HIGHWAYS ENGLAND RESPONSE TO

RELEVANT REPRESENTATIONS OF

CAMPAIGN FOR BETTER TRANSPORT AND FRIENDS OF THE EARTH

Drawing title ENVIRONMENTAL MASTERPLAN
REGULATION 4(2)(e)
SHEET 1 OF 61
THEALE

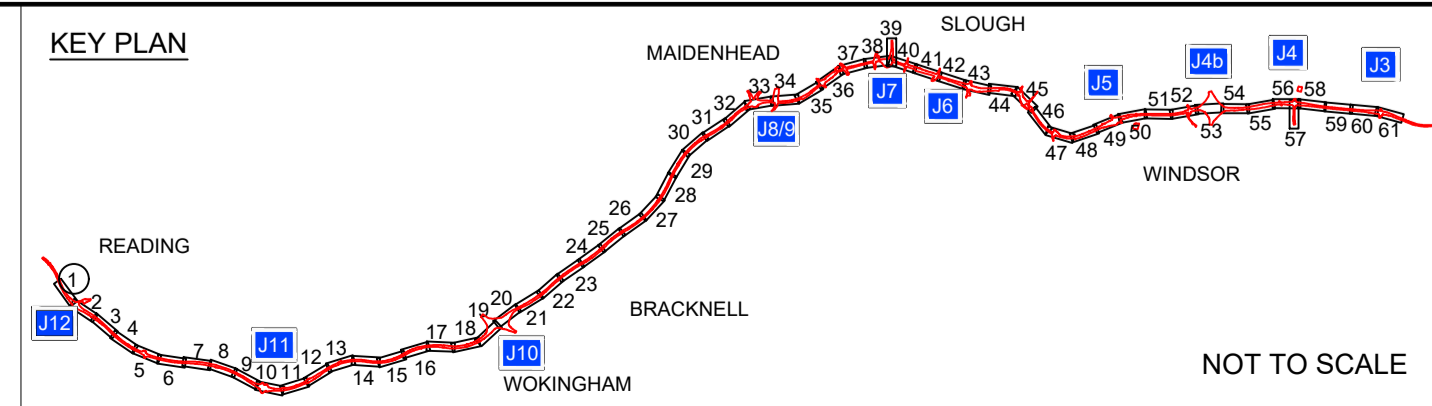
<p>capacity is considered.</p> <p>5. Impact on landscape and biodiversity</p> <p>As the M4 does not have a continuous hard shoulder, the Scheme entails a significant amount of new works, increasing the road's footprint on the landscape. It is hard to see how widening the road and disrupting the ecology of the surrounding land is compatible with Highways England's new Biodiversity Action Plan.”</p>	<p>Given that there was an identified need to improve the M4 motorway, as explained above, a range of options were investigated by Highways England as detailed in Section 5 of the EDR (Application Document Reference 7.3). The All Lane Running scheme taken forward made best use of the existing road infrastructure, thereby limiting the adverse impacts associated with adding lanes to the motorway.</p> <p>As stated in paragraph 9.4.3 of the ES (Application Document Reference 6.1), only small amounts of land within the Order limits will be permanently lost. There will be no permanent land take from designated sites or for habitats above those valued at the local level.</p> <p>As stated in paragraph 9.4.21 of the ES (Application Document Reference 6.1), in general, the soft estate is narrow, extending only a few metres from the toe of the hard shoulder to the highway boundary fence. However, some wider sections do exist, in particular, around junctions and bridges. The majority of the habitats are considered to be of no more than local value.</p> <p>As stated in paragraph 9.4.22 of the ES (Application Document Reference 6.1), vegetation removal within the Order limits will be minimised as far as possible and areas that are not cleared will be fenced off to prevent accidental incursions by construction plant. These include fencing to exclude incursions into the Root Protection Areas of trees as per BS 5837:2012, including those that lie immediately outside of the Order limits. Furthermore, as stated in paragraph 9.4.24 of the ES (Application Document Reference 6.1), land cleared of vegetation for temporary construction works will be replanted following construction. These will be native species appropriate to the local area, as illustrated</p>

<p>in the Environmental Masterplan (Annex A of the Engineering and Design Report) (Application Document Reference 7.4).</p> <p>As stated in paragraph 9.4.117, due to the small land take required for the Scheme, opportunities for enhancement measures are limited. However, in compliance with national policy including the National Networks National Policy Statement, and in compliance with Highways England's new Biodiversity Action Plan, opportunities for ecological enhancement have been sought to maximise the biodiversity benefits of the Scheme, as follows:</p> <ul style="list-style-type: none">• Any reinstatement of vegetation on the affected verges will include reseeding with an appropriate native wildflower seed mix and only native species will be used in any landscape planting. The removal of invasive species to prevent spread during construction could also result in a beneficial effect (paragraph 9.4.118 of the ES (Application Document Reference 6.1));• The Environmental Masterplan will incorporate native tree planting in any re-instatement of woodland, with an emphasis on fruit bearing varieties in areas identified as supporting foraging mammals and birds (paragraph 9.4.119 of the ES (Application Document Reference 6.1));• The Environmental Masterplan will incorporate the installation of otter ledges on culverts or under bridges where no ledge is currently present, in accordance with DMRB Volume 10 Section 4 Part 4. This will ensure improved habitat connectivity for otters (and water vole) beneath the Scheme and allow for adaptation to climate change (9.4.121 of the ES (Application Document Reference 6.1));• The Environmental Masterplan will incorporate the provision of approximately 60 bat boxes at suitable locations. A variety of boxes will be used to support a
